From: Gomez, Angela J.
Sent: Tuesday, August 04, 2020 2:02 PM
To: Gomez, Angela J.
Subject: FW: [#2020013] Wintergreen Apartments DRB questions (PR-2020-004030)

From: Richard Stevenson [mailto:rstevenson@tierrawestllc.com]
Sent: Tuesday, August 04, 2020 1:55 PM
To: Marsha Kearney
Cc: p crump; Ron Bohannan; rick@rba81.com; gnh5976@gmail.com; 1garciagang@gmail.com; mdmiraba@msn.com; meganfitz@live.com; bcreel@msn.com; frandimarco@msn.com; cfmirabal@gmail.com; ruffkat@yahoo.com; david.m.lopez@msn.com; garnand_lu@yahoo.com; kmcvey124@comcast.net; tjmurieta@msn.com; nenaperkin@gmail.com; avalgman12@gmail.com; scott.templeton@comcast.net; chavezdyx4@yahoo.com; mccormackdj@comcast.net; erin.coffman@yahoo.com; huerta.loretta58@gmail.com; gayle.binkley@me.com; marshakearney@gmail.com; nauticalhutch@gmail.com; miladybutler@yahoo.com; rfasel@fed.net; Gomez, Angela J.; Wolfenbarger, Jeanne; Gould, Maggie S.
Subject: RE: [#2020013] Wintergreen Apartments DRB questions (PR-2020-004030)

The intent of this email is to provide responses to the questions raised by neighbors at the DRB hearing on July 22nd 2020, in regards to the proposed Wintergreen Apartment project City project number PR-2020-00

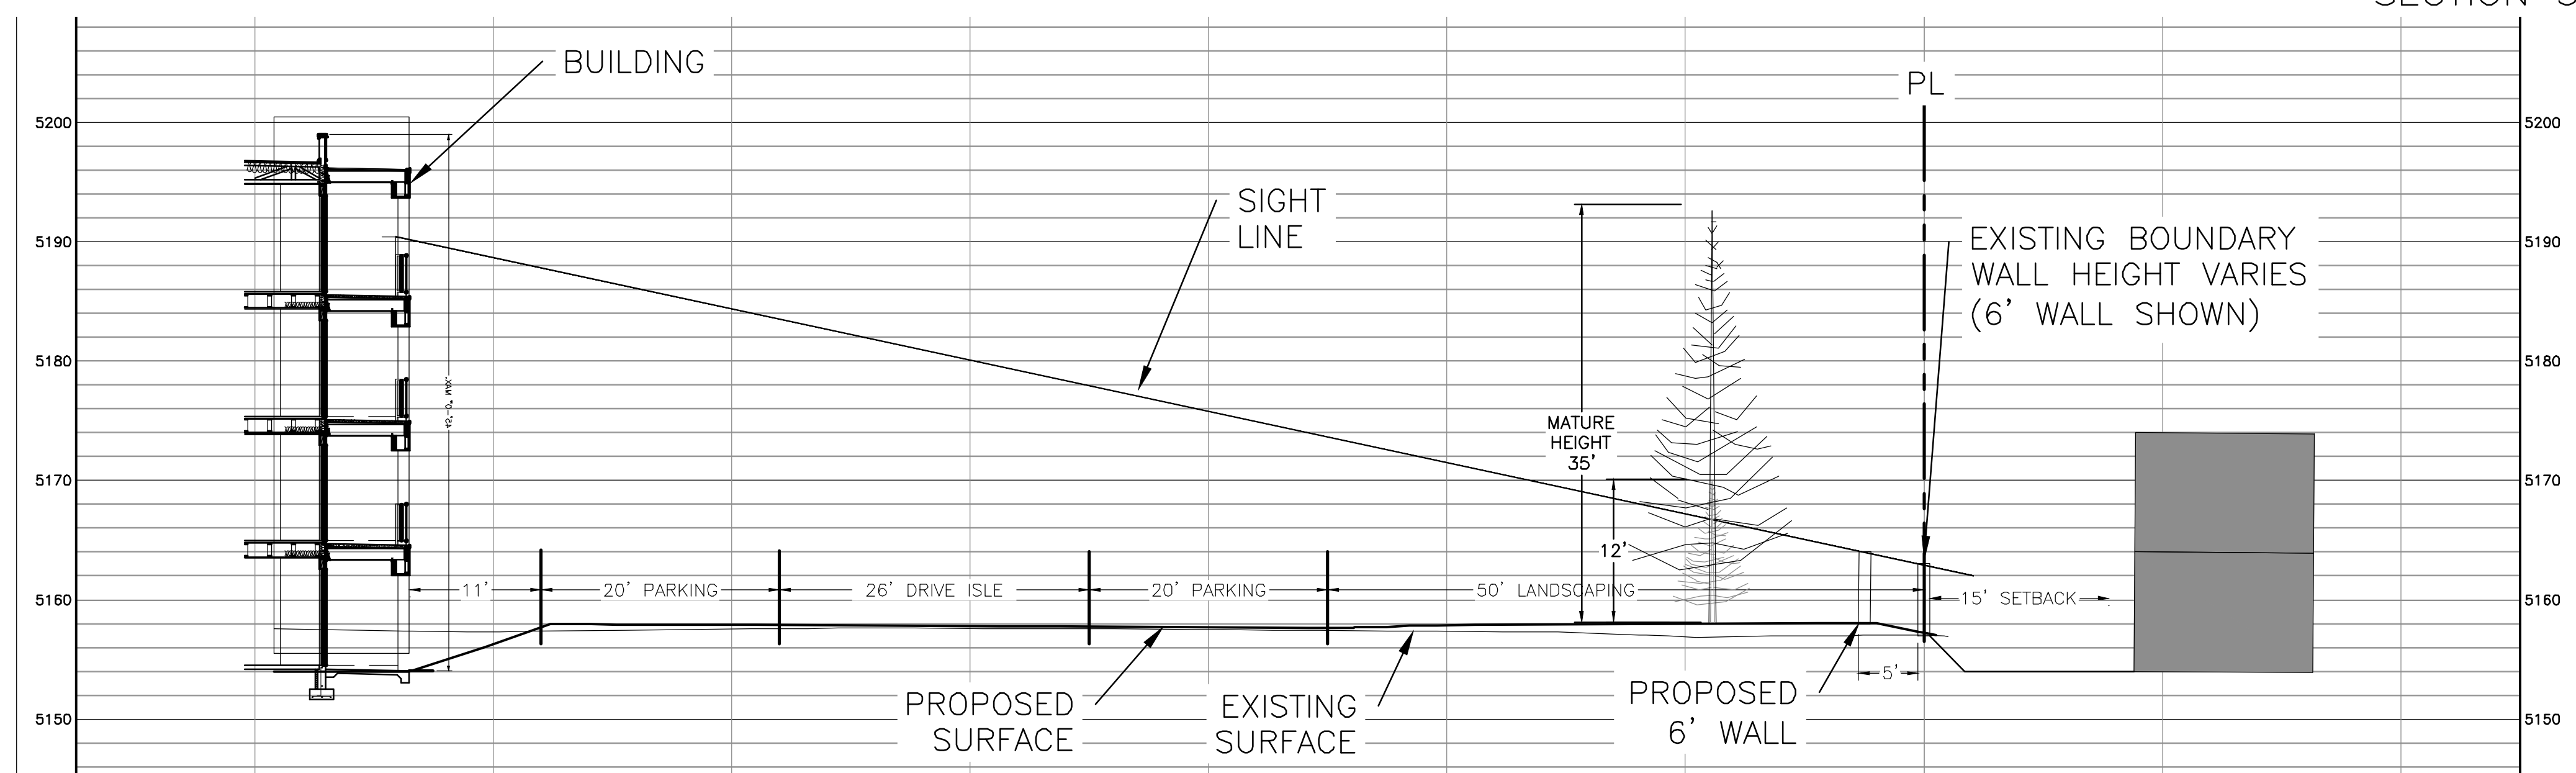
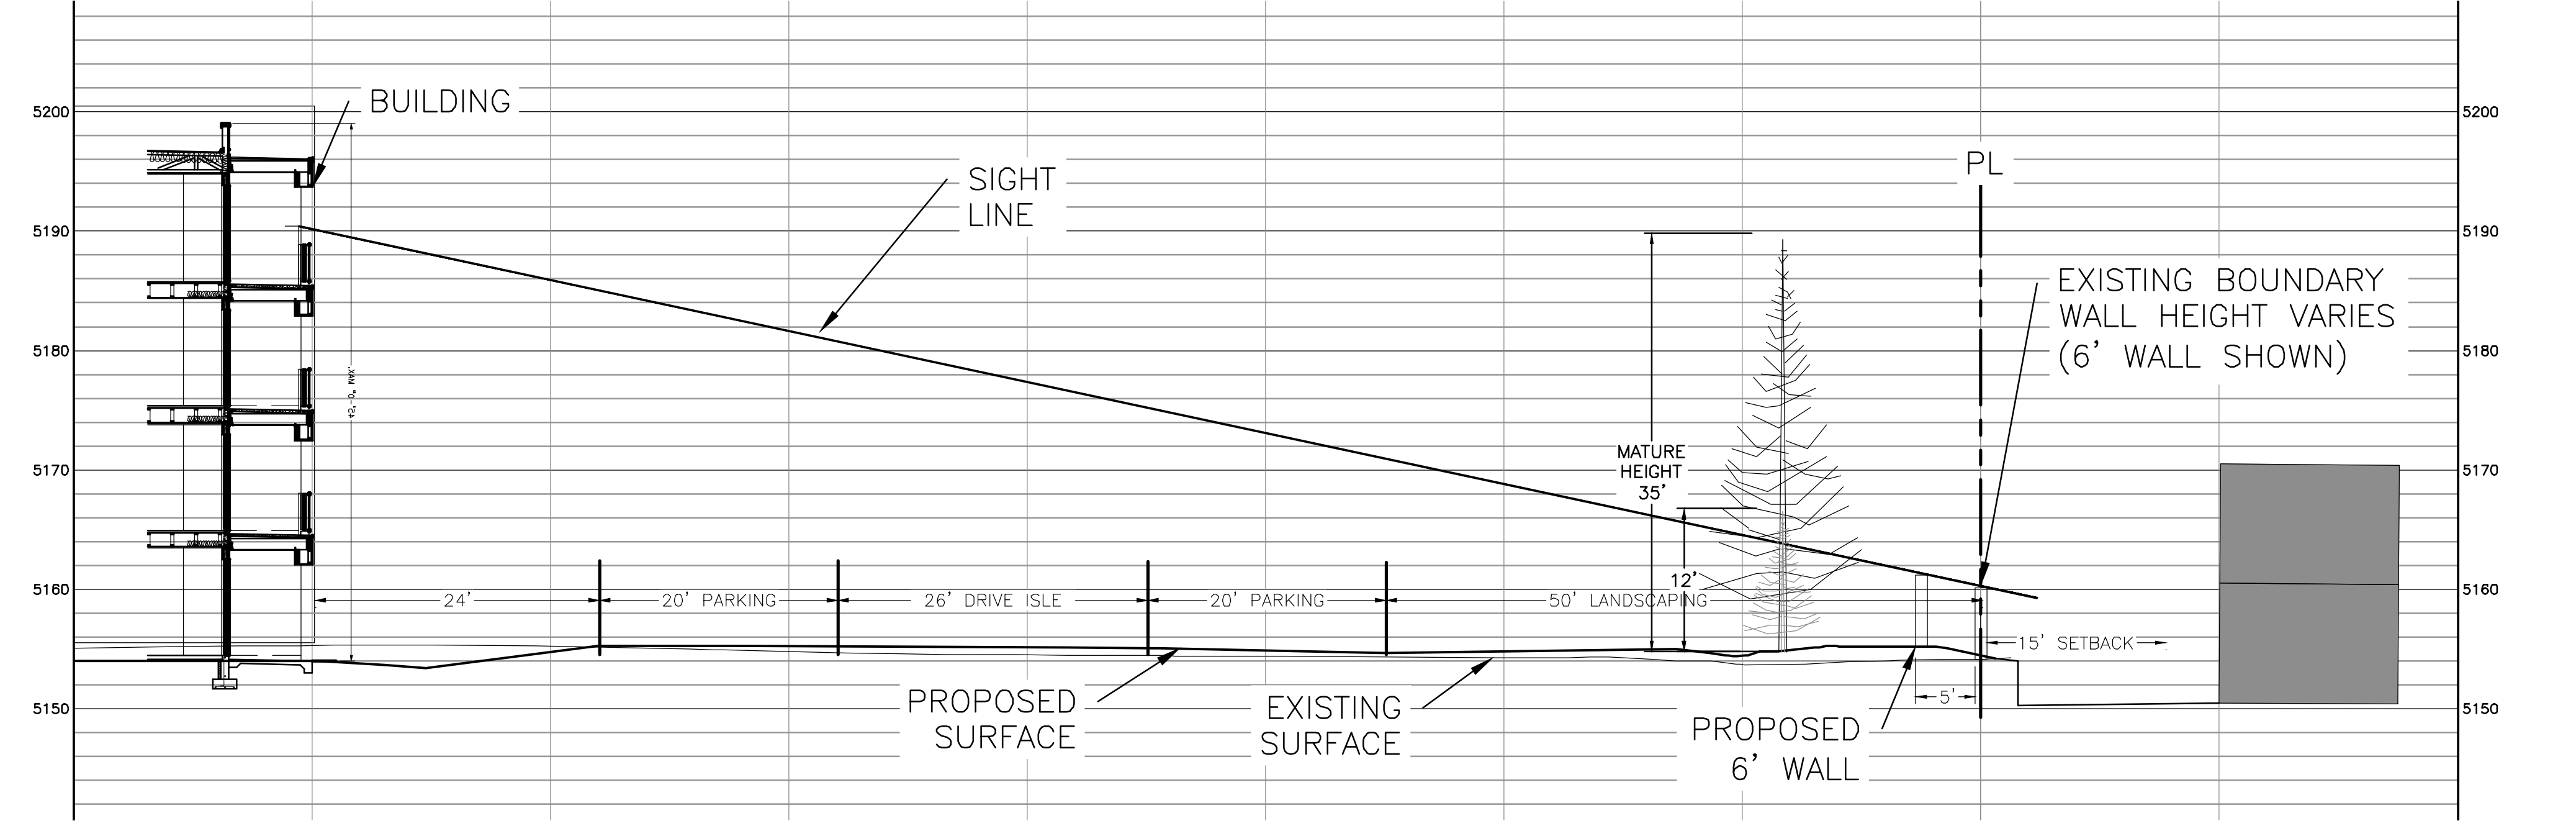
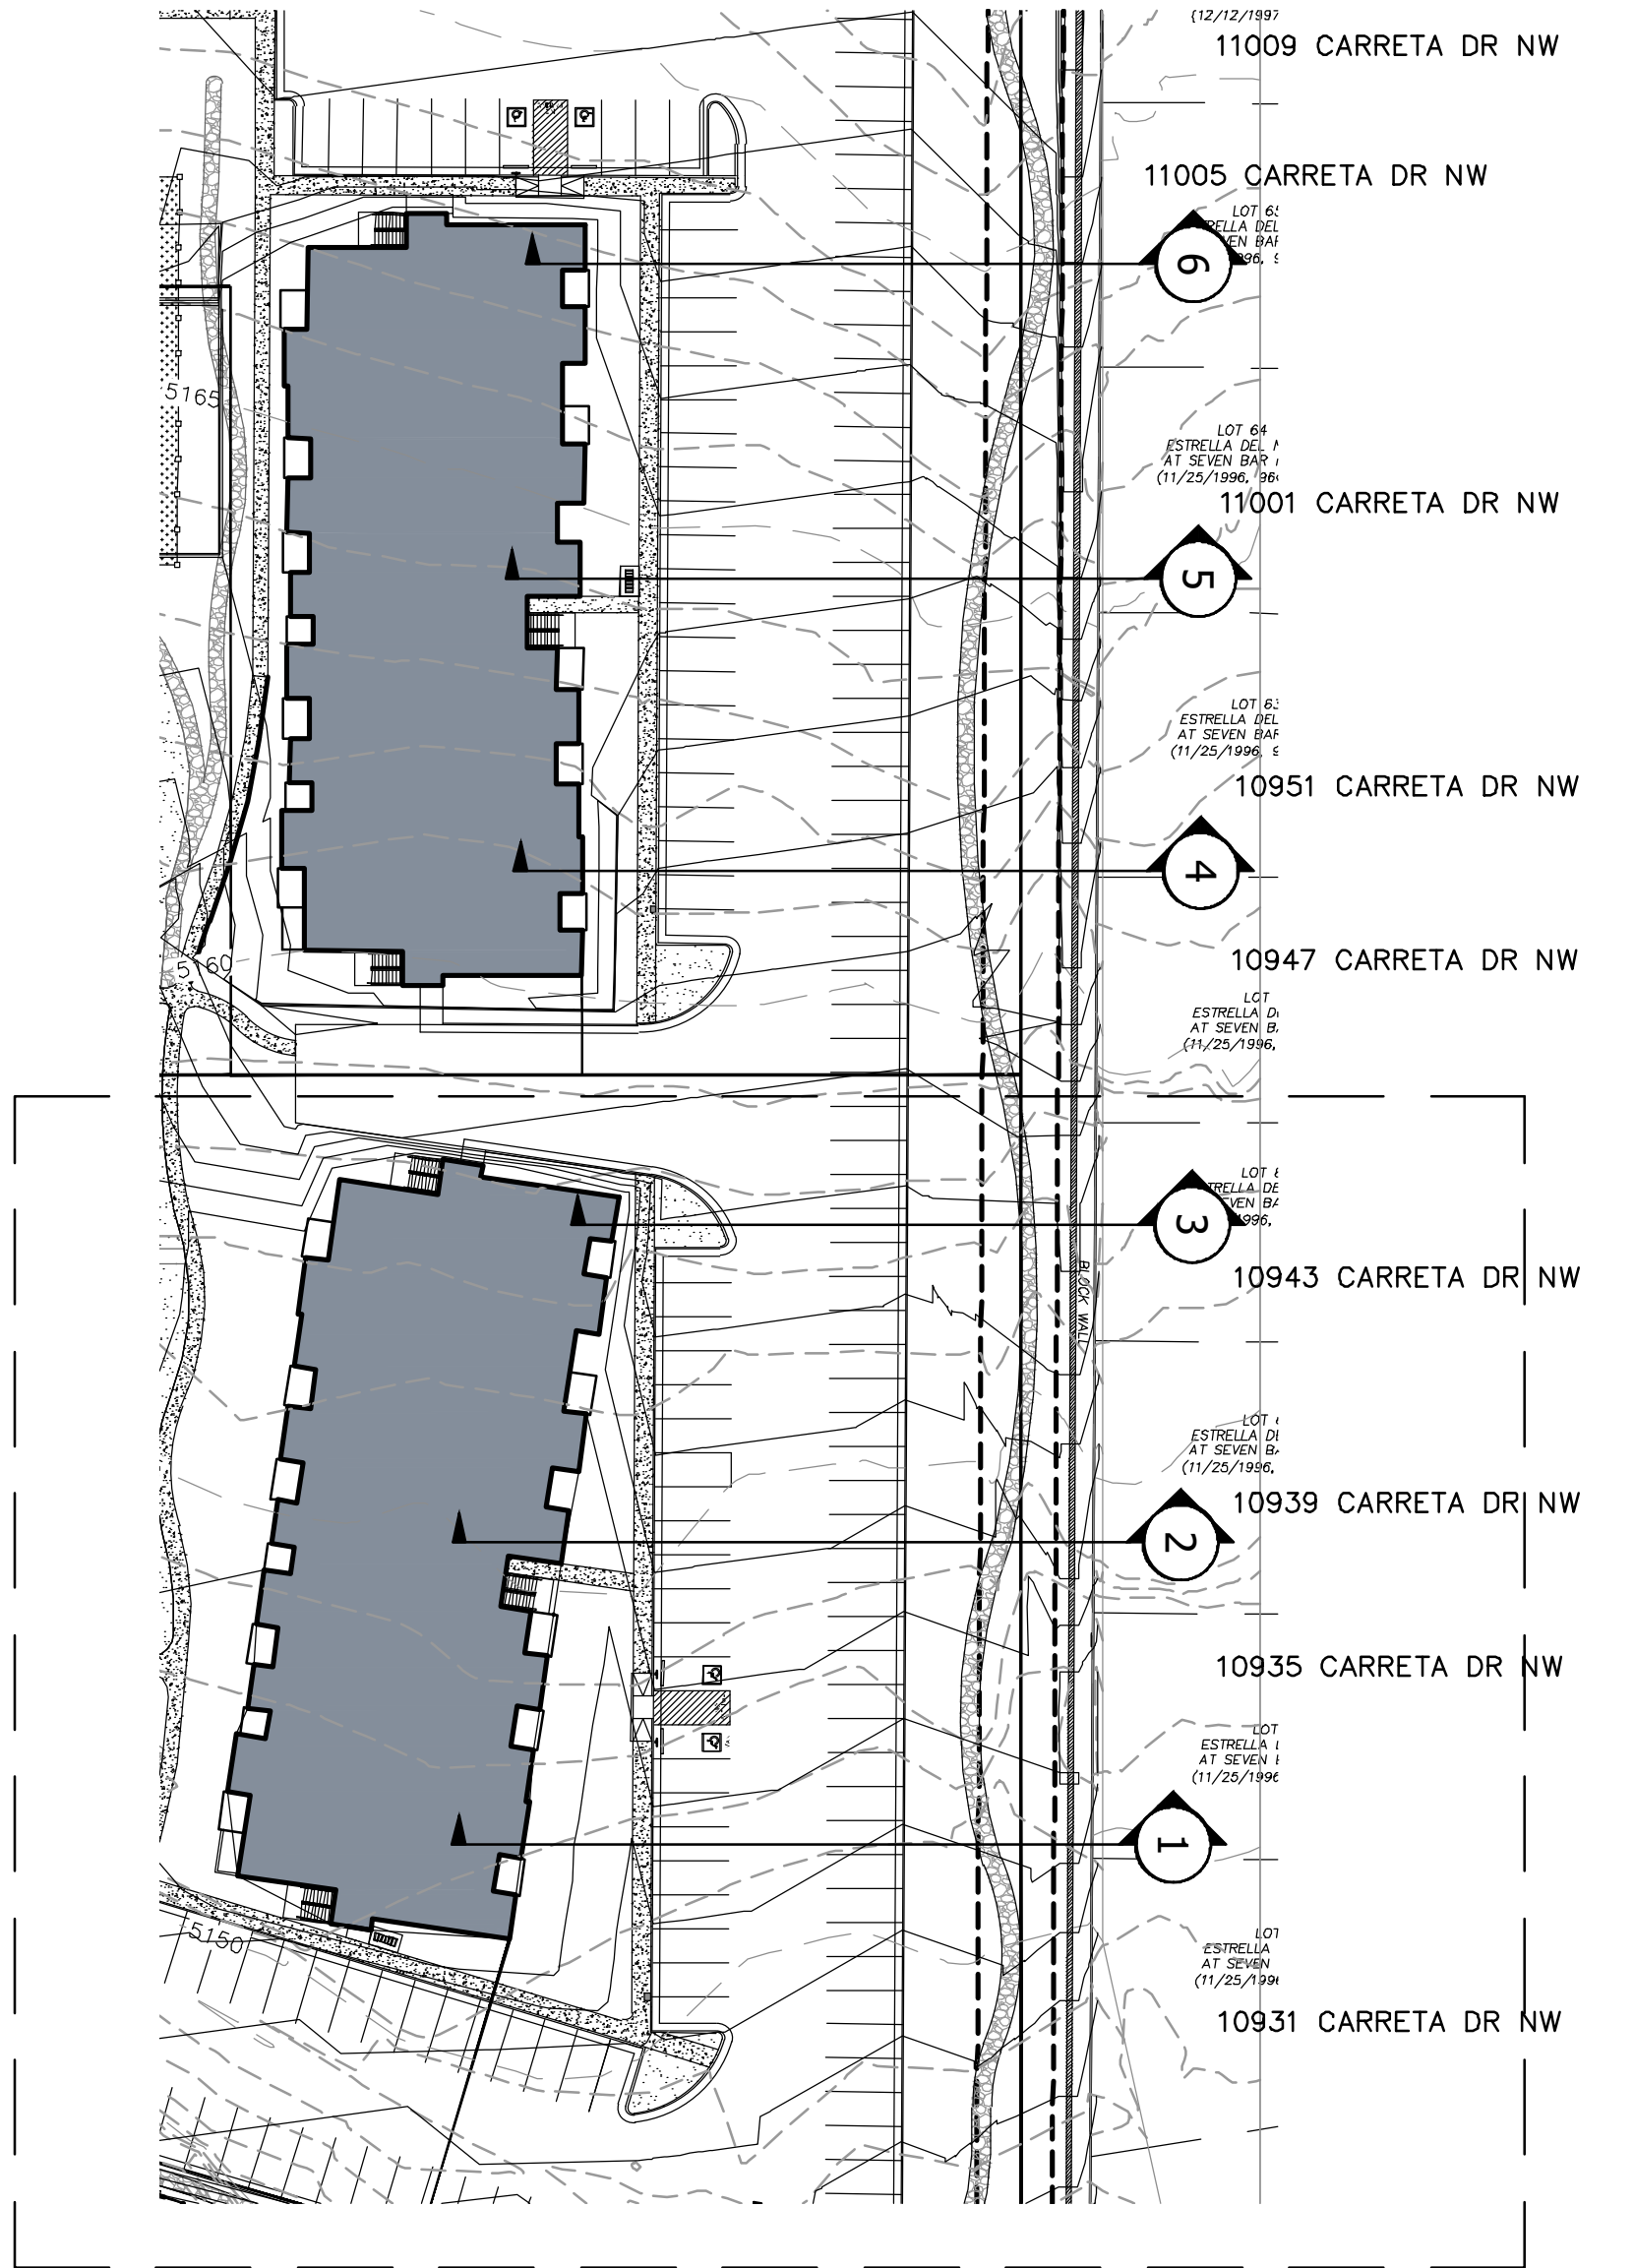
7. The cross-sections provided are inadequate when speaking to the privacy and noise barriers needed for the residents. Cross-sections show trees. Where exactly are they planted, spacing, heights, etc. We have no clear view of what will be in the buffer and how it will protect the adjacent property owners.

The tree sizes at planting and at maturity are shown in the cross sections to provide a scale and orientation of the apartment building relative to the single family homes and detail the buffer area. As previously mentioned the IDO requires a 50-ft landscape buffer (IDO Section 5-9(F)) to provide a setback between the improvements and the single family homes to increase the privacy and to reduce sight-lines from adjoining properties. Based on the proposed building height there is also a minimum 100-ft offset from the property line (IDO Section 2-4(C)), to provide protection to the adjacent home owners. Please refer to the landscaping plan which details the tree spacing, heights at maturity etc. which is included in the plans (link provided in previous email).
